DECISION DELEGATED TO HEAD OF PLANNING

Application No: H11-0780-23 **Applicant:** Mr K Bunn
Proposal: Proposed conversion of dwelling into 1 new house and 2 new flats
Location: 12 Park Lane Long Sutton Spalding
Terminal Date: 1st November 2023

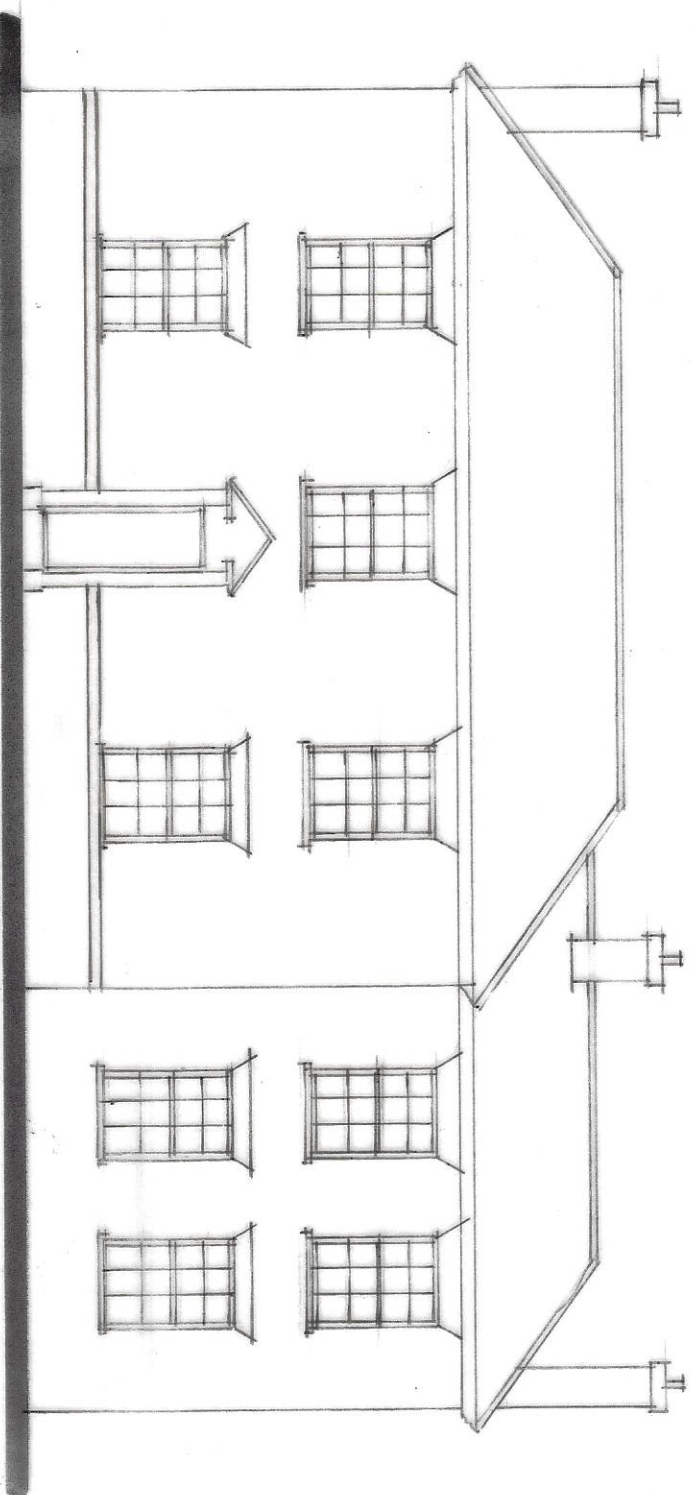
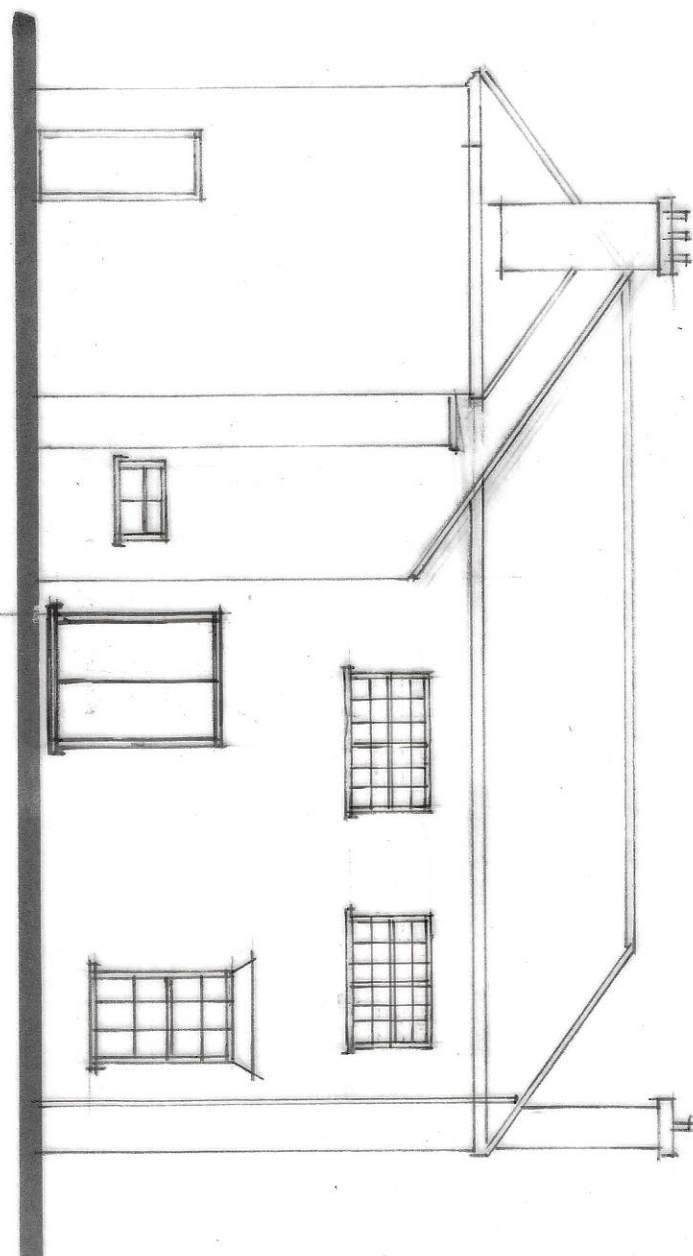
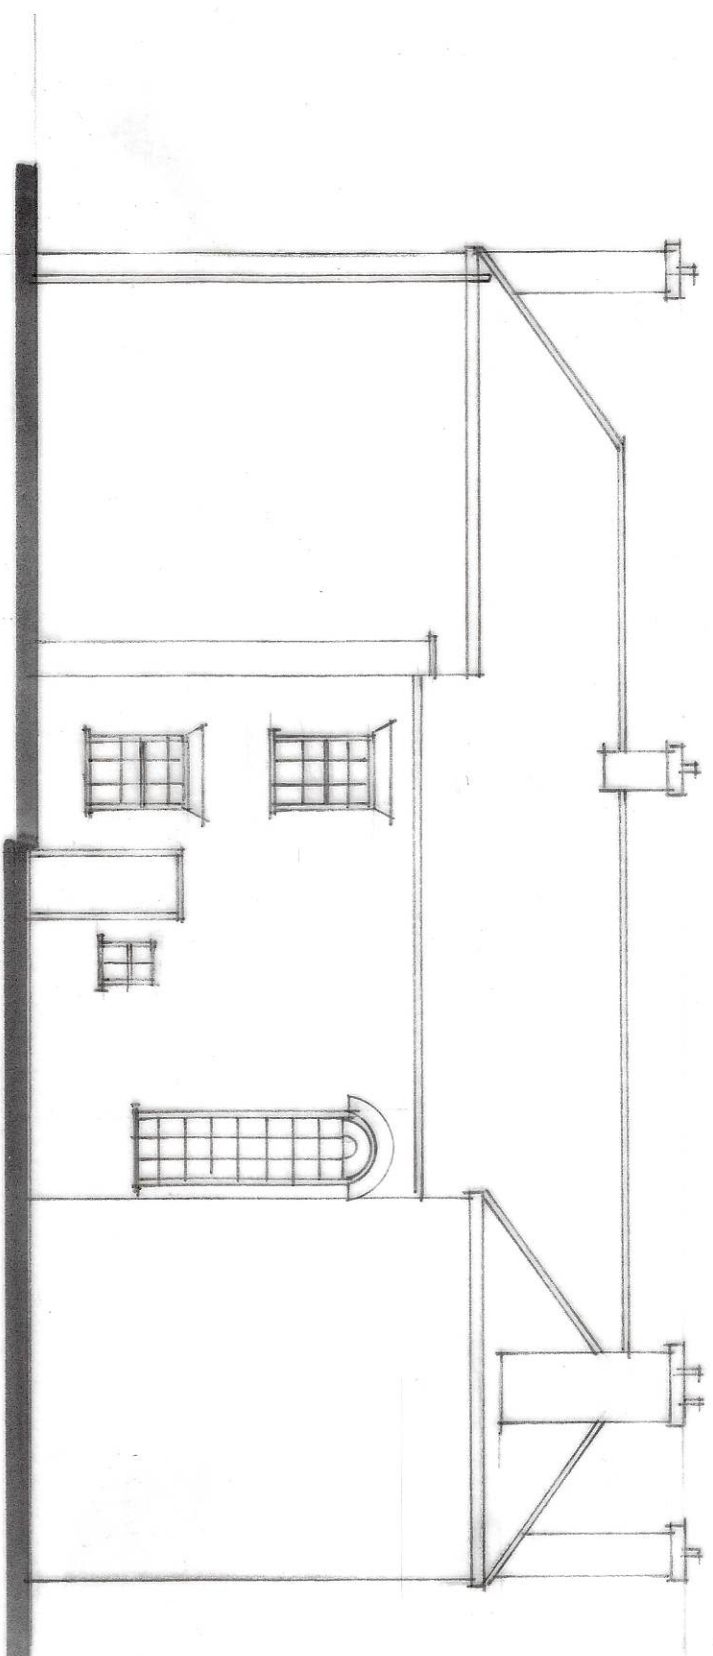
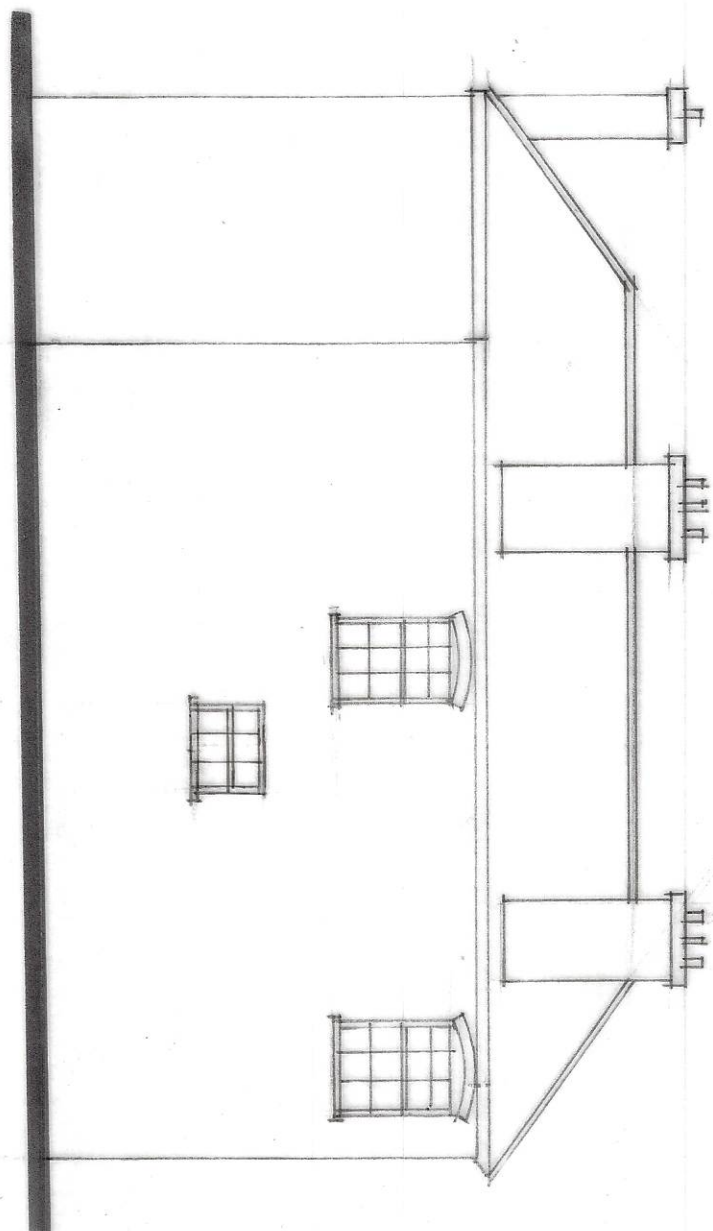
The proposed alterations involve the replacement of windows with non-traditional materials as well as the blocking up of doorways and creation of new openings, notably replacing an original window with French windows. NPPF 2023, para 194 states: 'In determining applications, local planning authorities should require an applicant to describe the significance of any heritage assets affected, including any contribution made by their setting. The level of detail should be proportionate to the assets' importance and no more than is sufficient to understand the potential impact of the proposal on their significance. As a minimum the relevant historic environment record should have been consulted and the heritage assets assessed using appropriate expertise where necessary.' Para 203 states: 'The effect of an application on the significance of a non-designated heritage asset should be taken into account in determining the application. In weighing applications that directly or indirectly affect non-designated heritage assets, a balanced judgement will be required having regard to the scale of any harm or loss and the significance of the heritage asset.' It is recommended that the applicant is required to submit a heritage statement which will identify the significance of the historic building and how any alterations to the historic fabric will affect that significance. It is suggested that the statement should include some historical and cartographic research, to demonstrate the development of the building, as well as photographs of the buildings elevations an interior to illustrate any historic fabric to be altered. This will enable the effect on the historic character of the building to be determined and whether any form of mitigation is required

The proposed alterations involve the replacement of windows with non-traditional materials as well as the blocking up of doorways and creation of new openings, notably replacing an original window with French windows. NPPF 2023, para 194 states: 'In determining applications, local planning authorities should require an applicant to describe the significance of any heritage assets affected, including any contribution made by their setting. The level of detail should be proportionate to the assets' importance and no more than is sufficient to understand the potential impact of the proposal on their significance. As a minimum, the relevant historic environment record should have been consulted and the heritage assets assessed using appropriate expertise where necessary.'

Whilst taking into account a balanced judgement in terms of the internal state of the building, the lack of the submission of a heritage statement which would have identified the significance of the historic building and how any alterations to the historic fabric would affect that significance, particularly on the surrounding Conservation Area, and any required mitigation, the proposal is contrary to policy 29 of the SELLP which seeks to identify a heritage asset's contribution to the local community and surrounding Conservation Area.

SITE PLAN

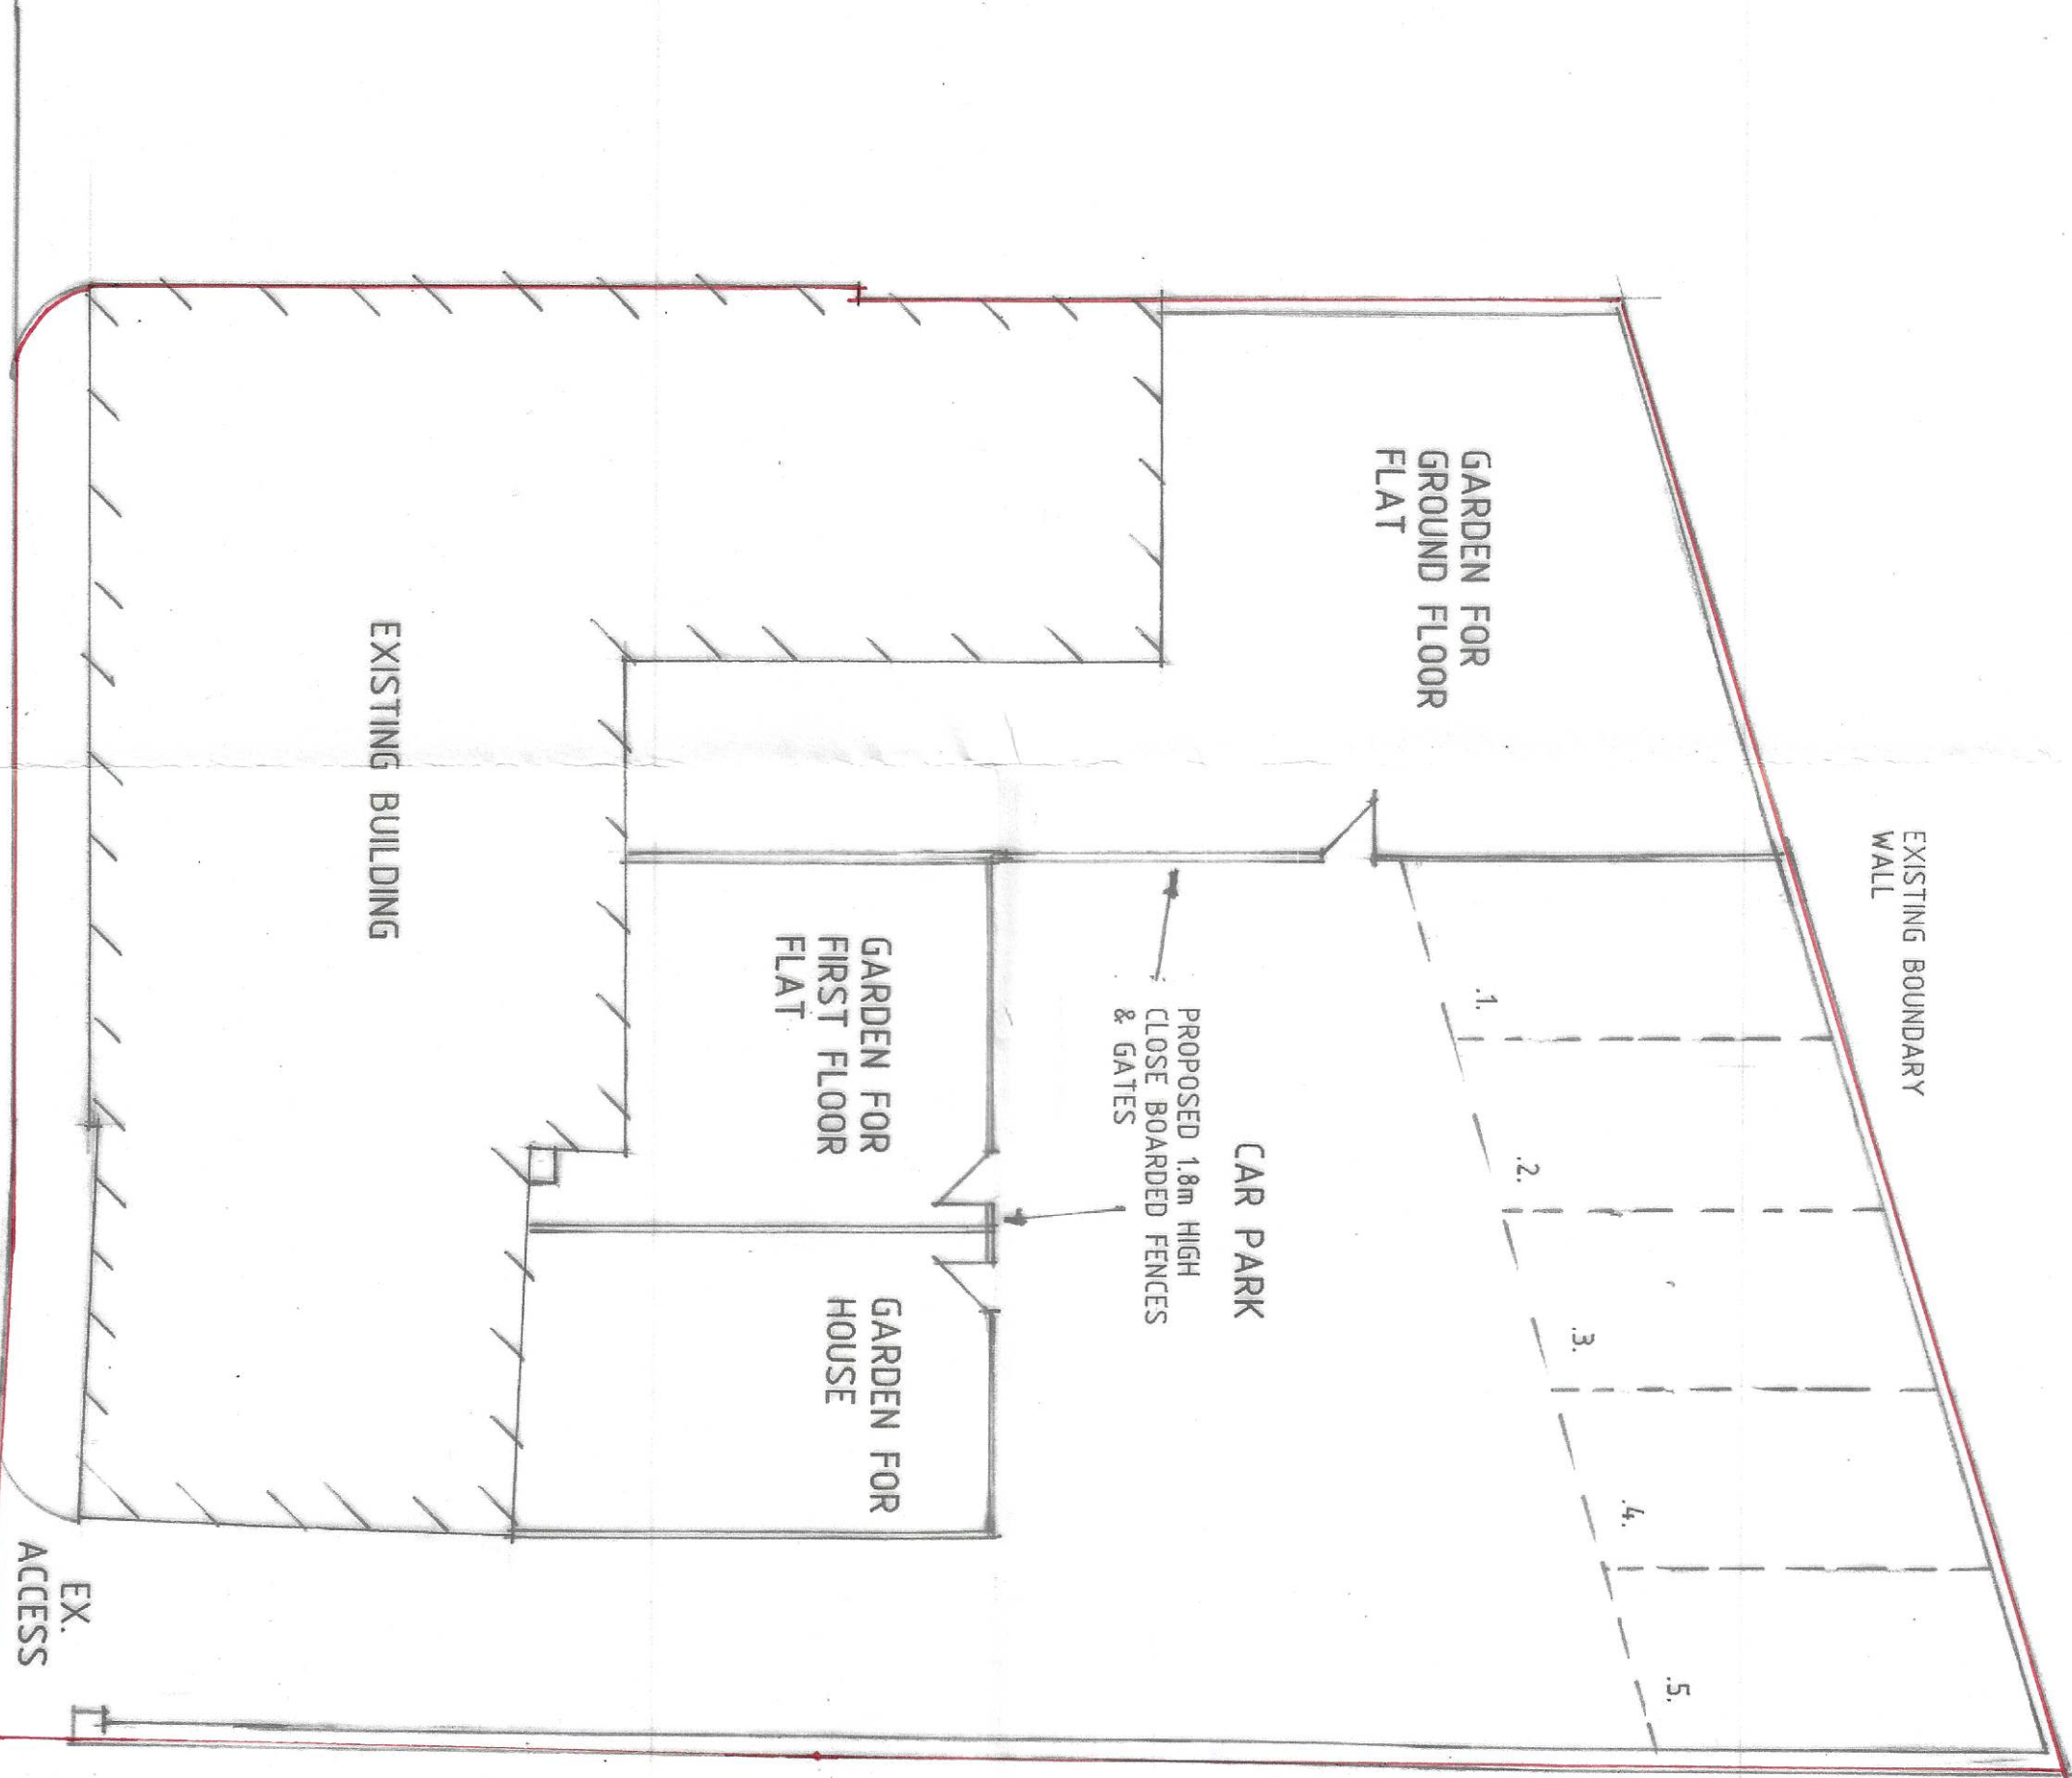
The proposed one bedroomed house has a rear amenity space of 26.4 square metres. The four bedroomed first floor flat has a rear amenity space of 25.4 square metres. The ground floor two bedroomed flat has a rear amenity space of 71.8 square metres.

It is considered that a rear amenity area of 71.8 square metres for the ground floor flat is reasonable, especially given that this is a 2 bedroomed flat. In area terms, rear amenity spaces of 26.4 and 25.4 for the house and four bedroom flat is considered to be poor, and overall too small, particularly for a four bedroom flat which could accommodate a family. This represents poor design, and an indication that too many dwellings are being proposed onto the site.

The rear garden depths for the dwellings are 6.34m for the one bed house, 6.36m for the four bedroomed first floor flat and 6.19m and the two bedroomed ground floor flat. The rear garden depths are considered to be inadequate. Coupled with the inadequate nature of the rear amenity space (in terms of area) for the one bedroomed house and the first floor flat, this constitutes poor design, and is not 'planning for beauty' that the government now promotes.

Overall, it is considered that the amount of rear amenity space in terms of area for the one bedroomed house, and the restricted length of rear gardens for all 3 dwellings is poor in design terms, and inadequate for future occupiers of the dwellings, as well as adversely affecting the character and appearance of the area. It is considered this is insufficient and contrary to policy 21 which specifically requires an adequate standard of residential accommodation and residential amenity is provided for future occupiers, Policy 3 in that the scheme fails to create a distinctive places through the use of high quality and inclusive design and layout and Policy 2 in that it adversely affects the character and appearance of the area due to its poor quality of design.

The proposed development is for 3 dwellings in total and proposes 5 car parking spaces, arranged in a linear arrangement along the rear boundary in a line, set behind the amenity space in a yard. This is contrary to Appendix 6 given that 7 car parking spaces and 3 cycle parking spaces would be required for this development to be policy compliant. No cycle parking spaces are shown as part of the proposals. No transport assessment has been submitted which justifies the lack of adherence to adopted policy. The proposal is contrary to Appendix 6 and Policy 36 of the SELLP.

The design arrangement for the parking is considered to be poor. Policy 36 states that parking for residents and visitors should be integral to the design and form of all new development, and should ensure that parking spaces are fit for their intended use in terms of size and design, and that parking is well-integrated within the townscape or landscape, through an appropriate use of materials and landscaping. The parking is added into the rear yard in an awkward design arrangement, with a very restricted distance of 5.77m between the rear of the car parking spaces and the edge of the amenity space. The width of the access is 2.71m wide. Whilst it is acknowledged that the proposal does not attract an objection from the Local Highway Authority, the design of the rear parking arrangement is considered to be poor, and its design, due to its poor design is likely to lead to future occupiers not being able to use the parking effectively and would park on the street. The design of the rear parking is also considered to be contrary to policy 36 of the SELLP.
